Application Reference: BN/18/25/DOC Site Name: Eastmere Stables Eastergate Lane Eastergate PO20 3SJ	Initial Issue Date: 07/10/2025 Issue Date: 07/10/2025 Reviewer Reference: ADC/EXT4
--	---

Condition 9: **Objection**

Surface Water Drainage Comment Tracker

Name  
Project code  
Original Functional Spatial Form  
AAL436-AAL-ED-XX-DD-C-5550-C04

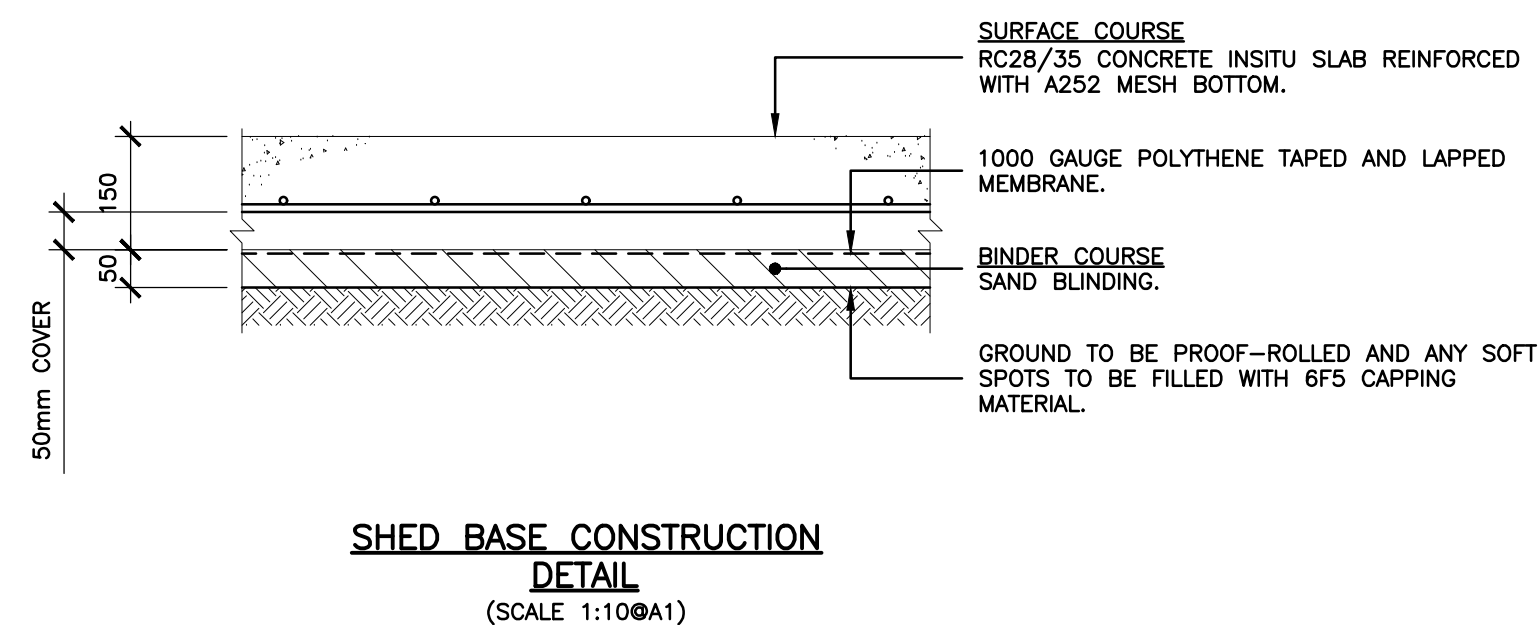
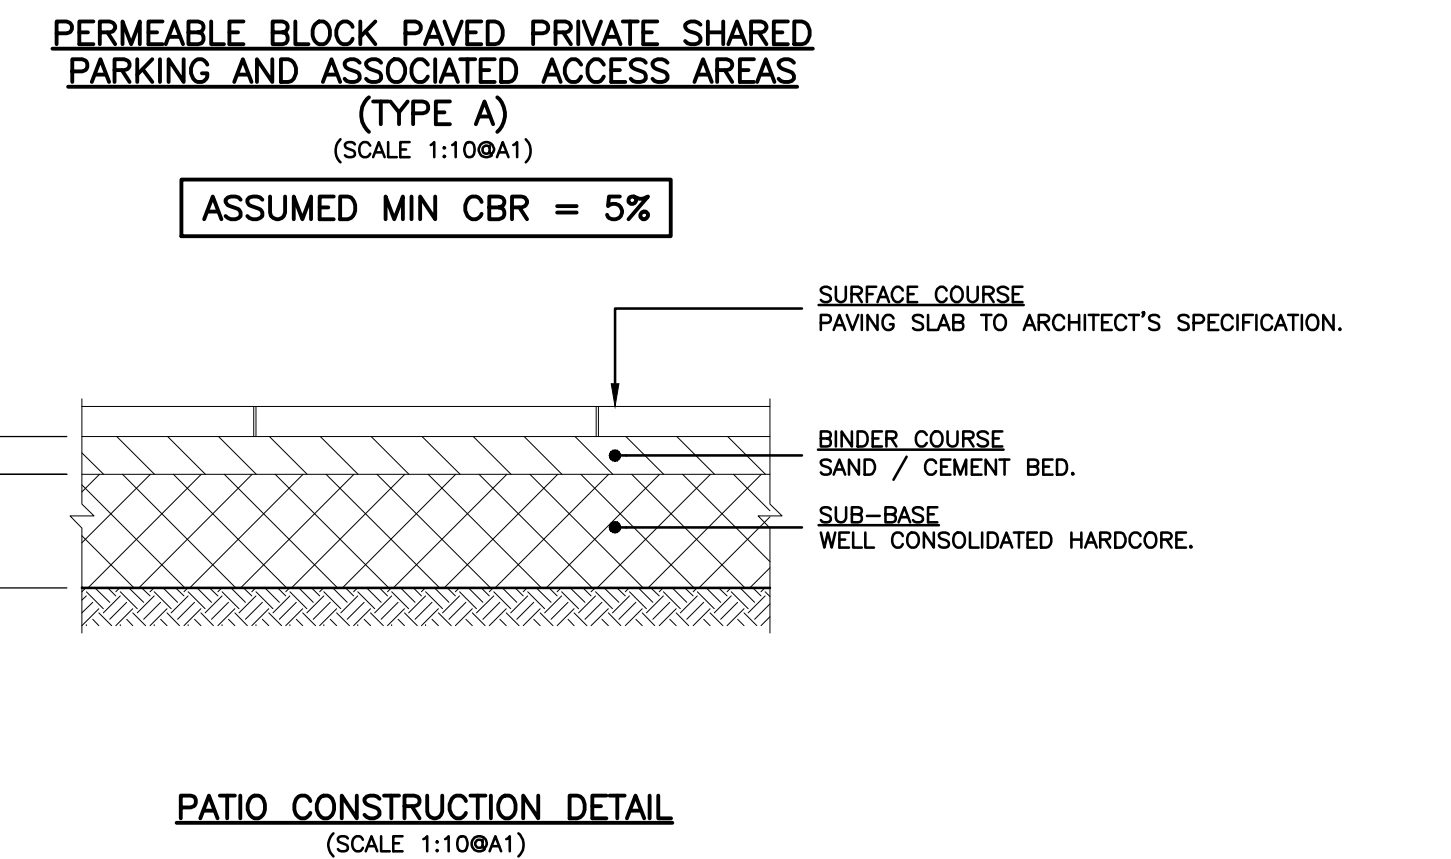
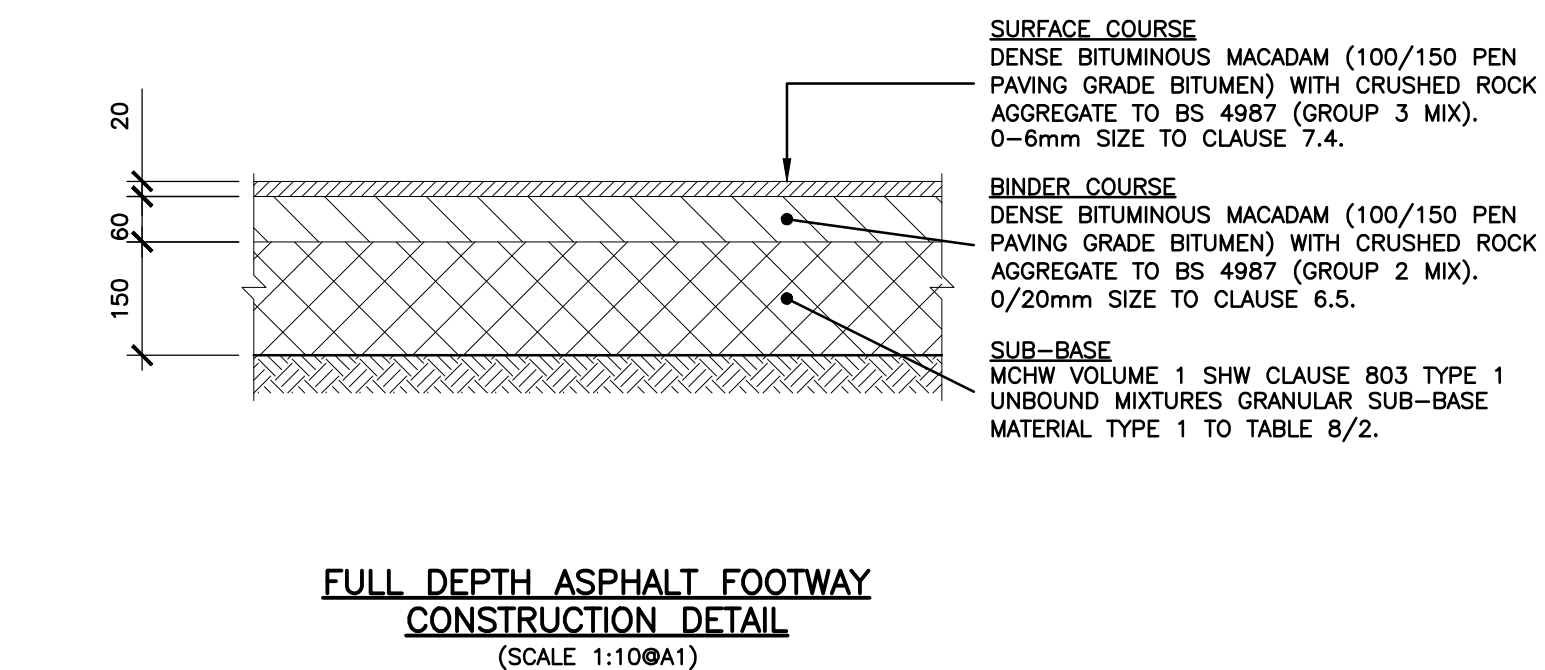
7.	ADC response (BN/18/25/DOC) 17/04/2025 There are occasions where the pipe cover depth near the plots is less than 0.6m. In these occasions concrete bed and surround should be provided. Designer response (BN/18/25/DOC) 17/04/2025 This is covered by the pipe bed and surround details on drawing 5550, which note the differentiation based on location and cover depth. The pipes referred to here would be class Z bedding. ADC response (BN/18/25/DOC) 18/08/2025 The construction details only refer to verges and carriageways. Please adjust to include areas around buildings/in gardens.	Notes now added to also include gardens.	Thank you item now closed	Noted

14.	Catchpit manhole construction detail – there appears to be text written over text. Please adjust.	Notes tidied up	Thank you item now closed	Noted	
15.	Provide full construction details for channel drain.	Added to drawing	Thank you item now closed	Noted

| Scale        | Paper size | Date       | Drawn by | Checked by | Status    |
|--------------|------------|------------|----------|------------|-----------|
| Project code | AAL436     | -AAL-      | ED       | -XX-       | LS-C-5102 |

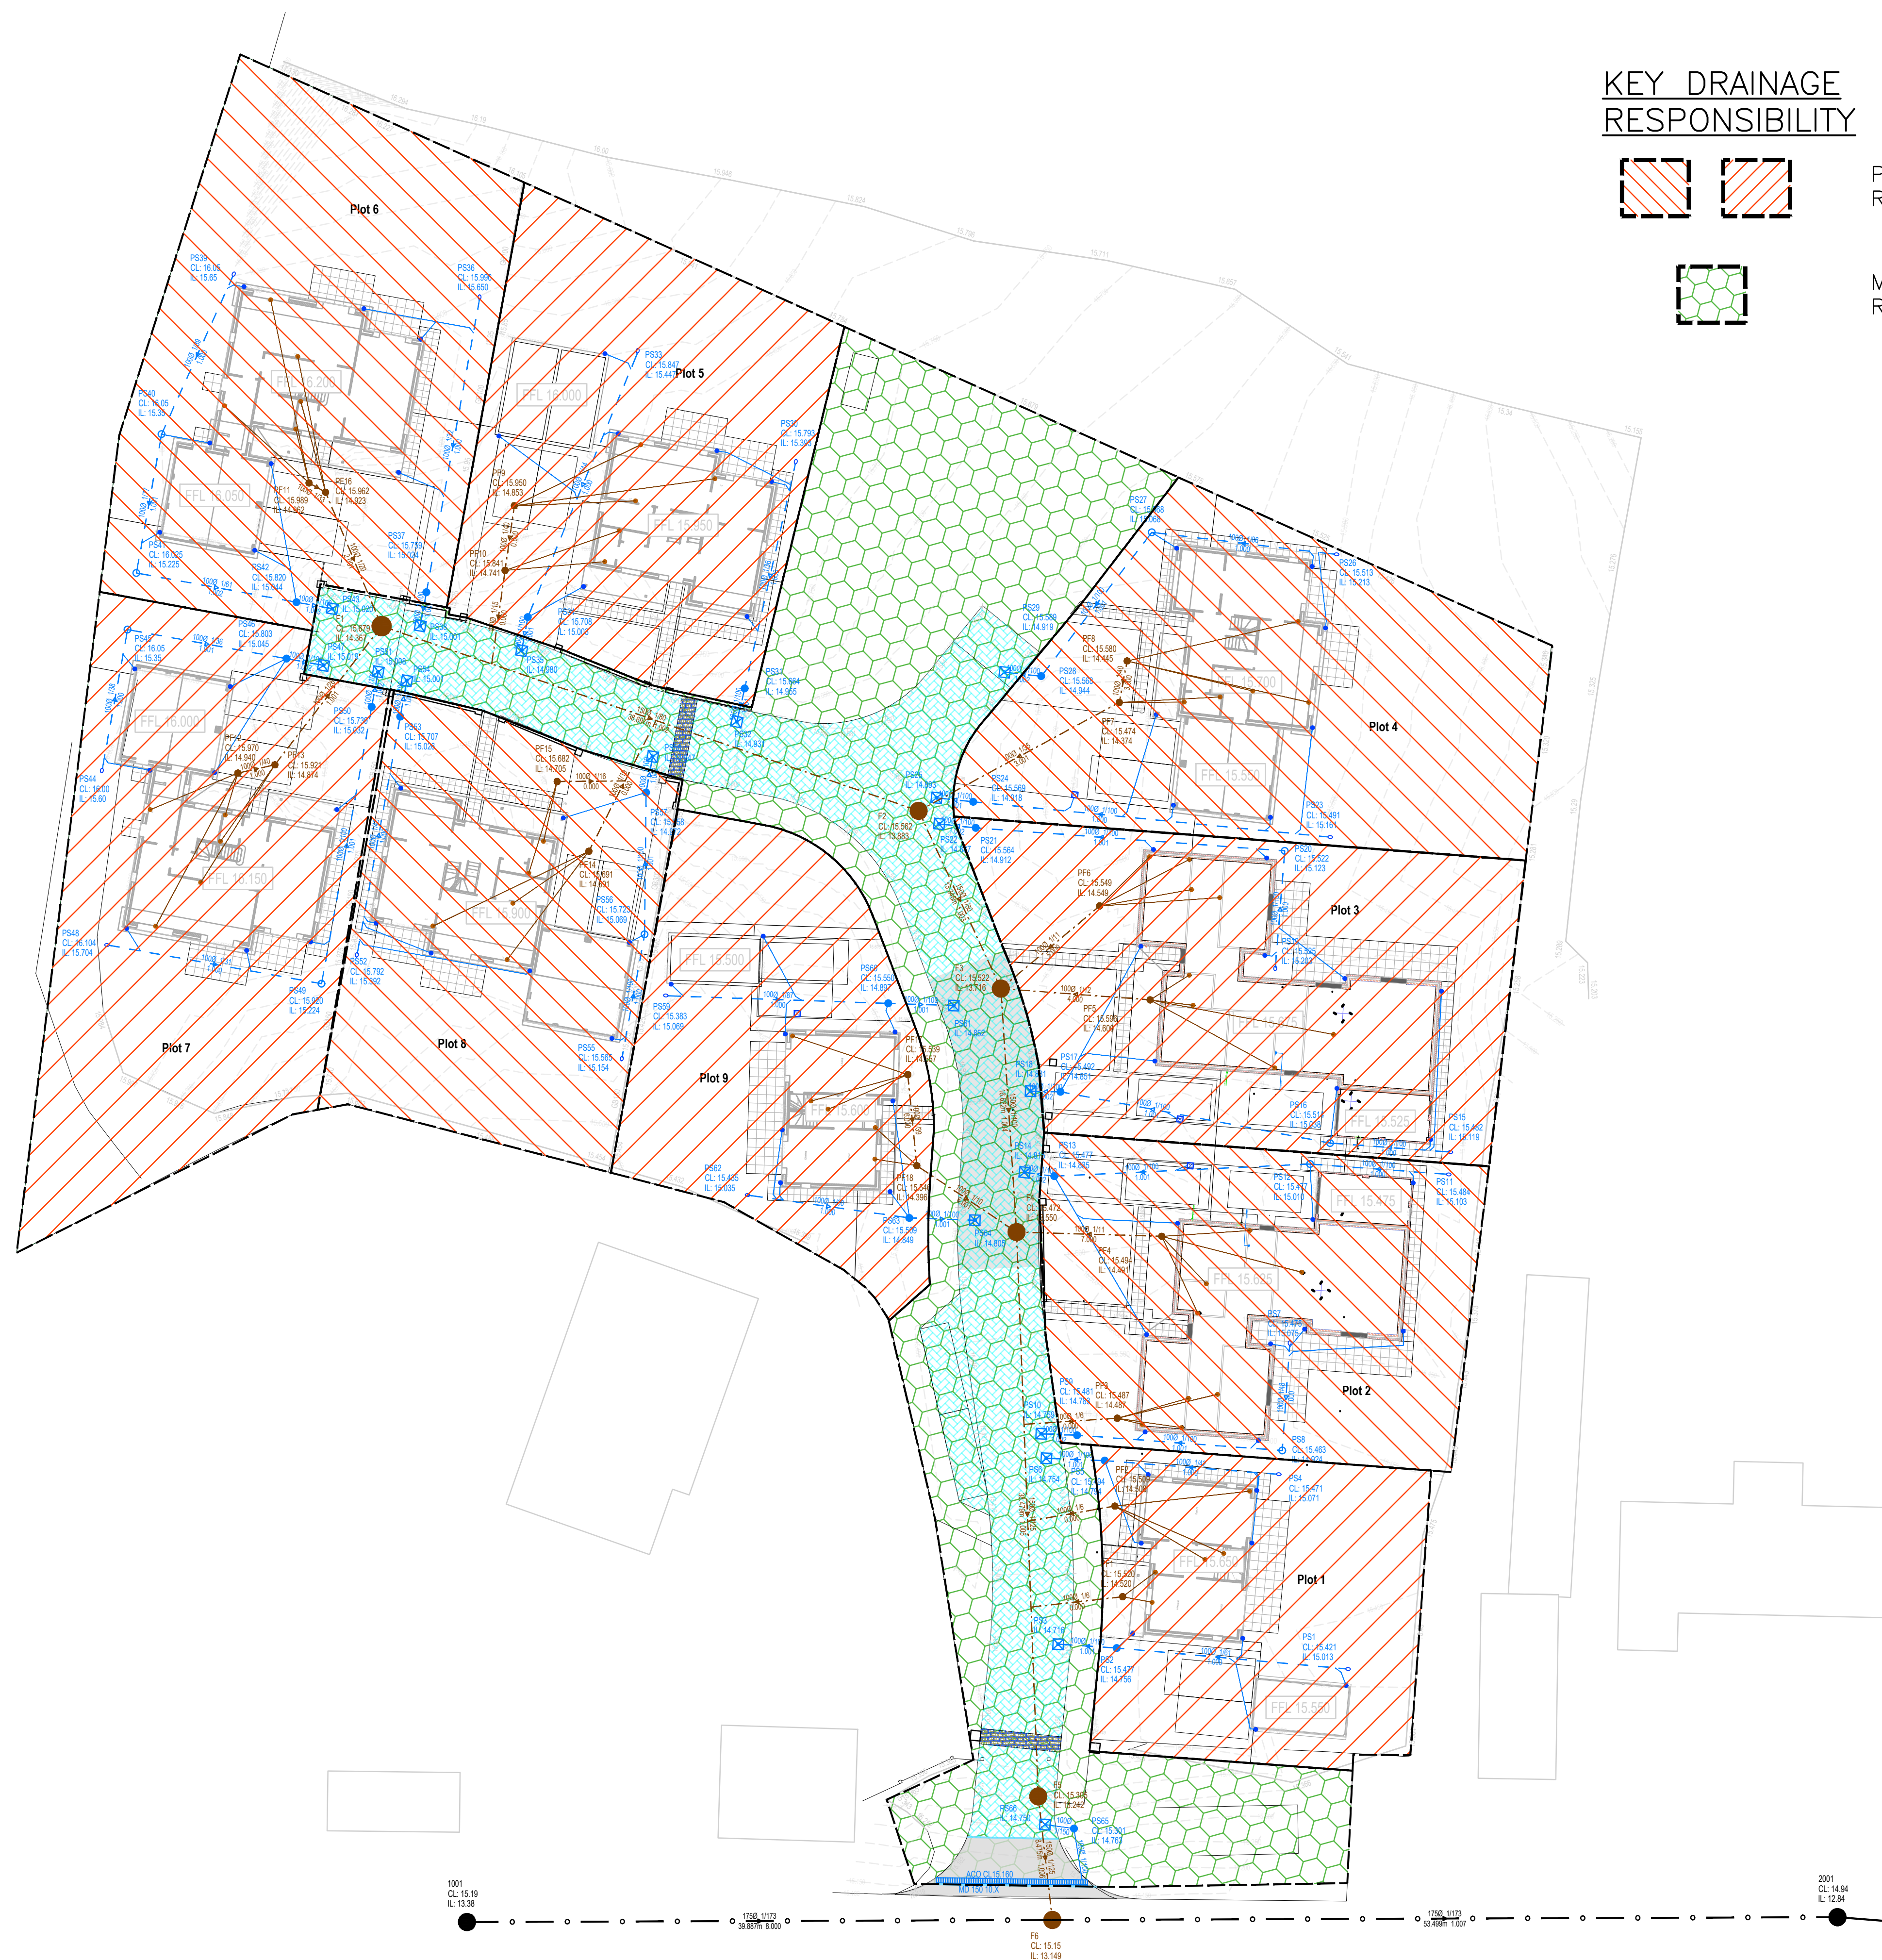
16.	Drg 5102 – notes 29 and 30 are irrelevant to this scheme – please remove.	Removed from drawing.	Thank you item now closed	Noted	
DRAINAGE MAINTENANCE PLAN

Scale	Paper size	Date	Drawn by	Checked by	Status
1:250	A1	FEB 2025	JH	CH	S0
Name					
Project code	Original	Functional	Spatial	Form	Number
AAL436-AAL-SF-XX-DR-C-5101					c05

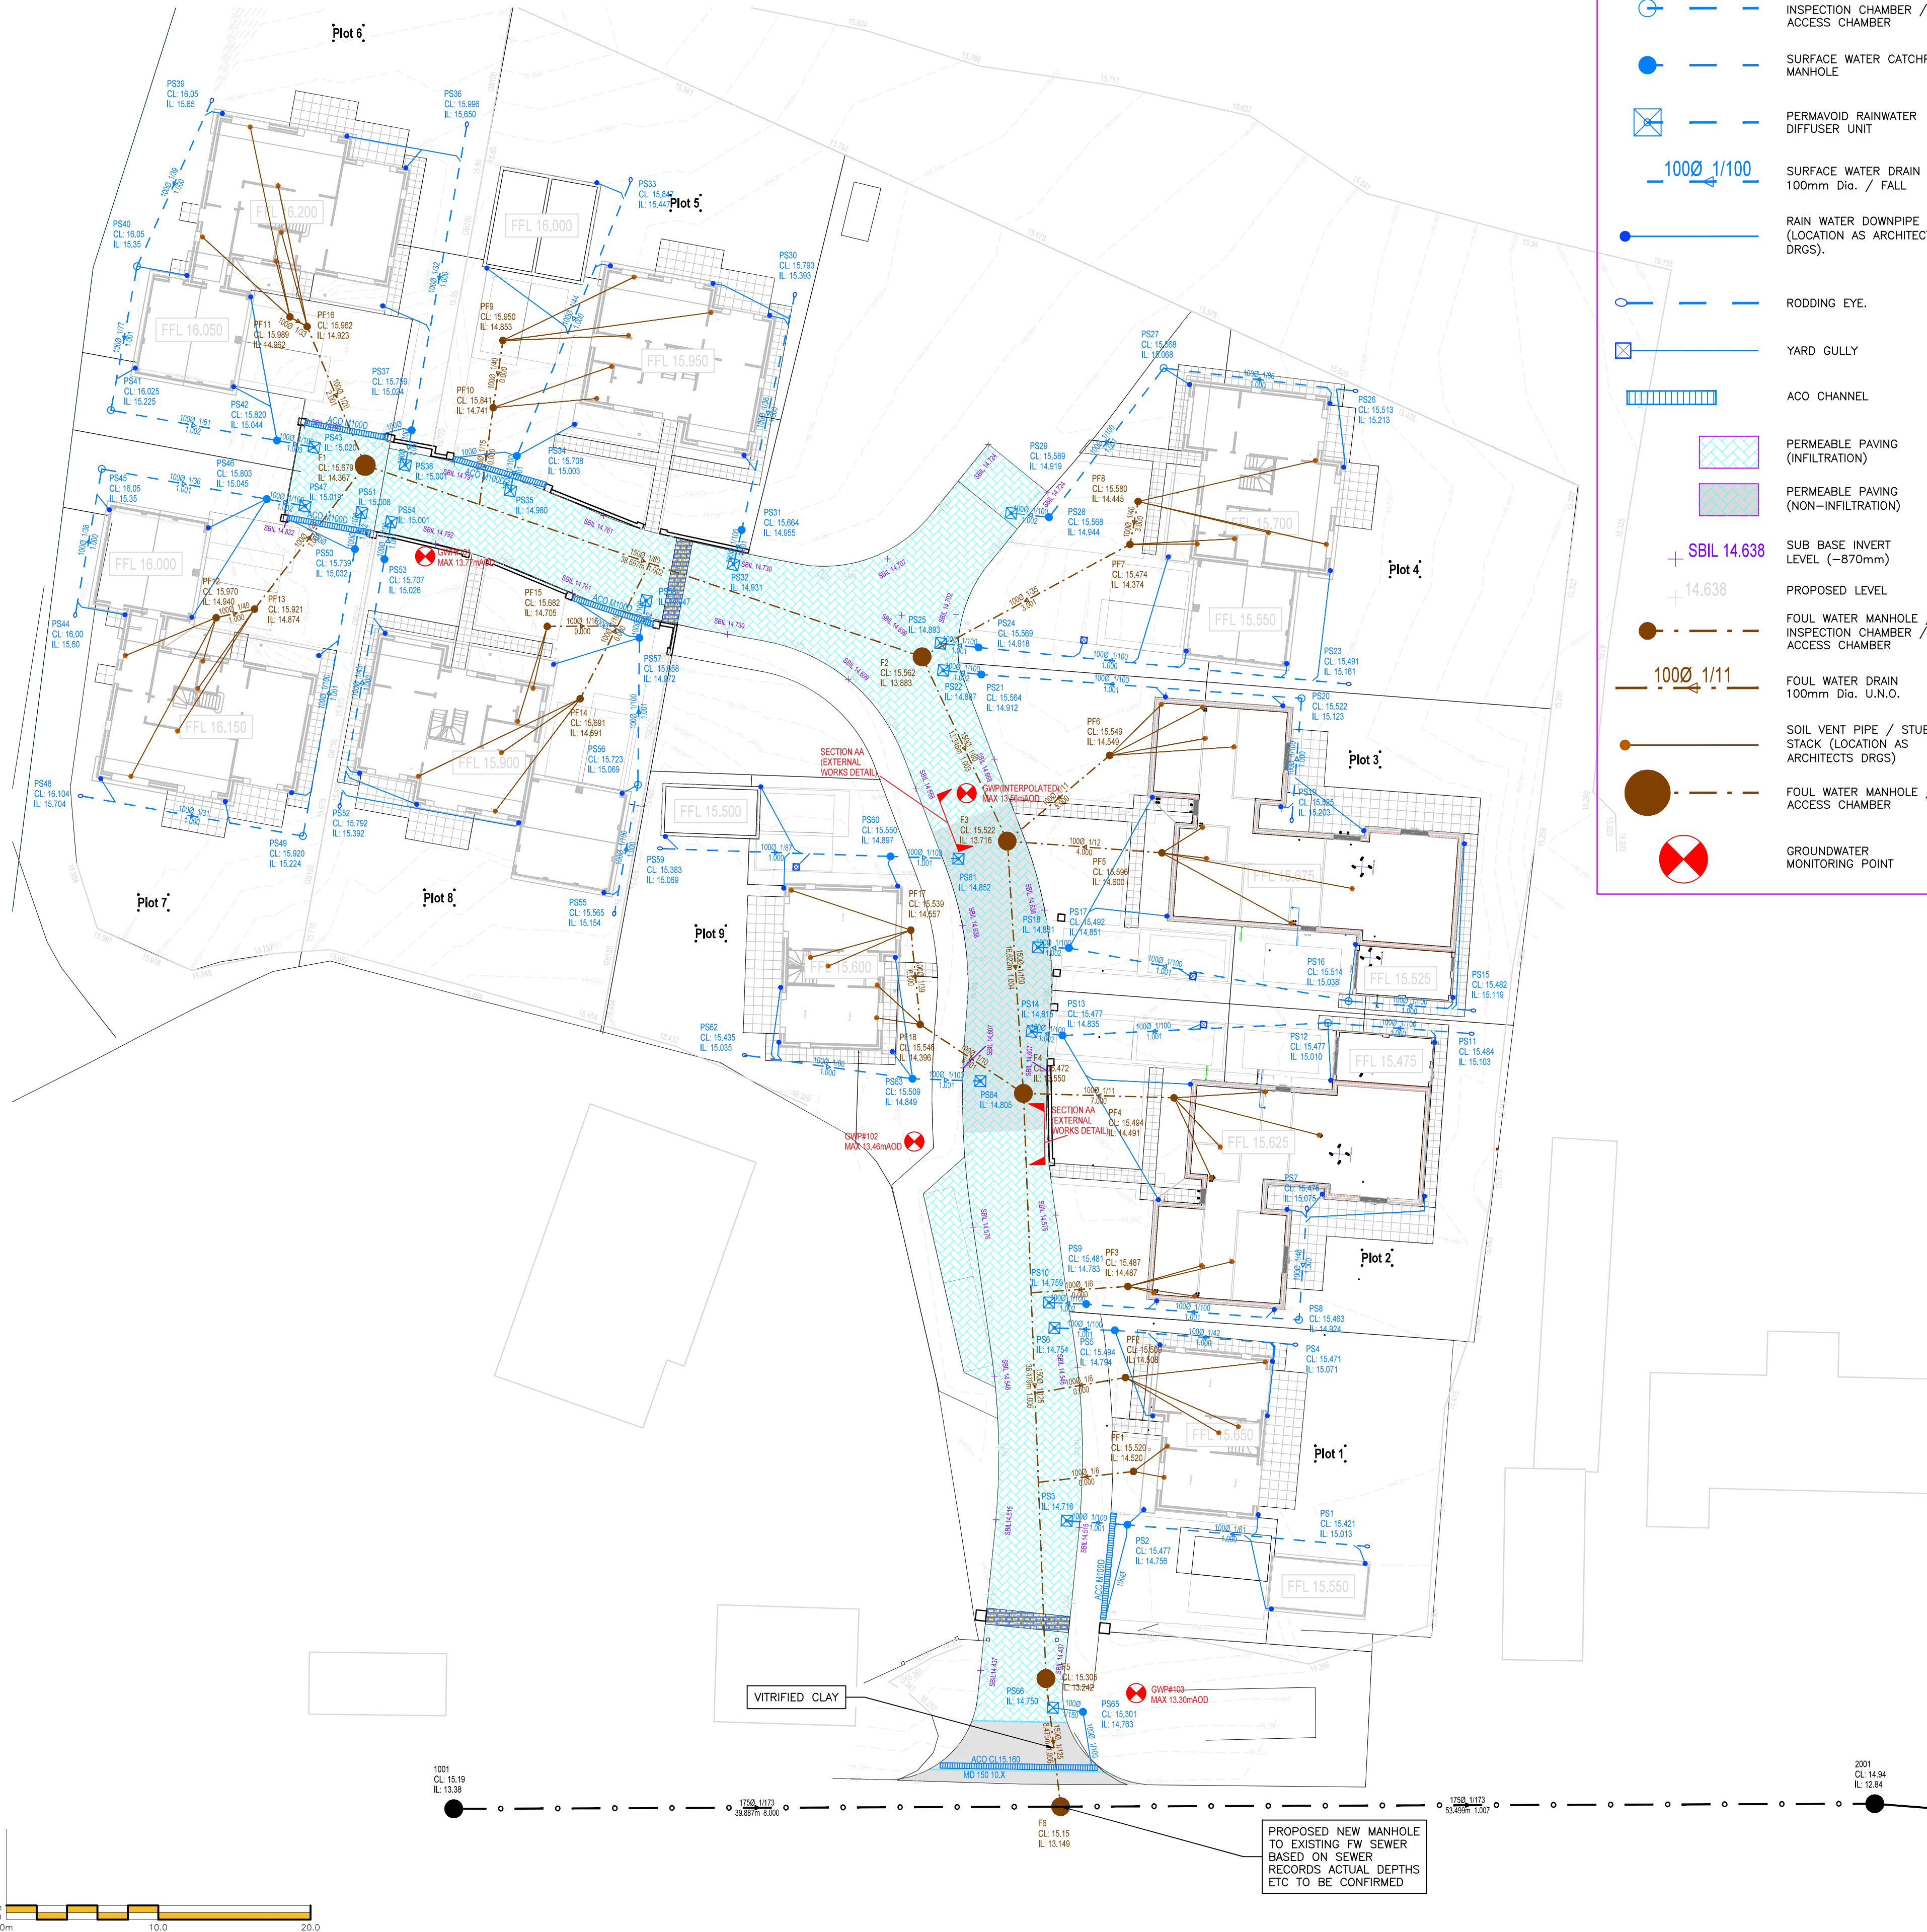
8.	Indicate permeable paving formation levels on drainage layout plan, for the entire length of permeable road.	This has now been added via 'SBIL' level annotation.	Thank you item now closed	Noted

9.	Catchpits are required immediately upstream of all diffuser units.	Missing catchpits added to drawing and table	Thank you item now closed	Noted	
10.	Specify all levels associated with the channel drain at the site entrance (ie. Outlet invert, manhole cover and invert, diffuser unit invert. Pipe diameters and gradients also to be shown.	Now added to drawing	Thank you item now closed	Noted

11.	All pipes not connecting to manholes to be connected via oblique 45 degree junctions. Please specify.	Pipes and connection where needed now show oblique connection	Thank you item now closed	Noted

12.	No pipes to connect against the direction of flow, examples; Connection to manhole north east corner of plot 9 & north side of plot 3.	Pipes updated to show oblique connections to remove apparent against flow connection	Thank you item now closed	Noted
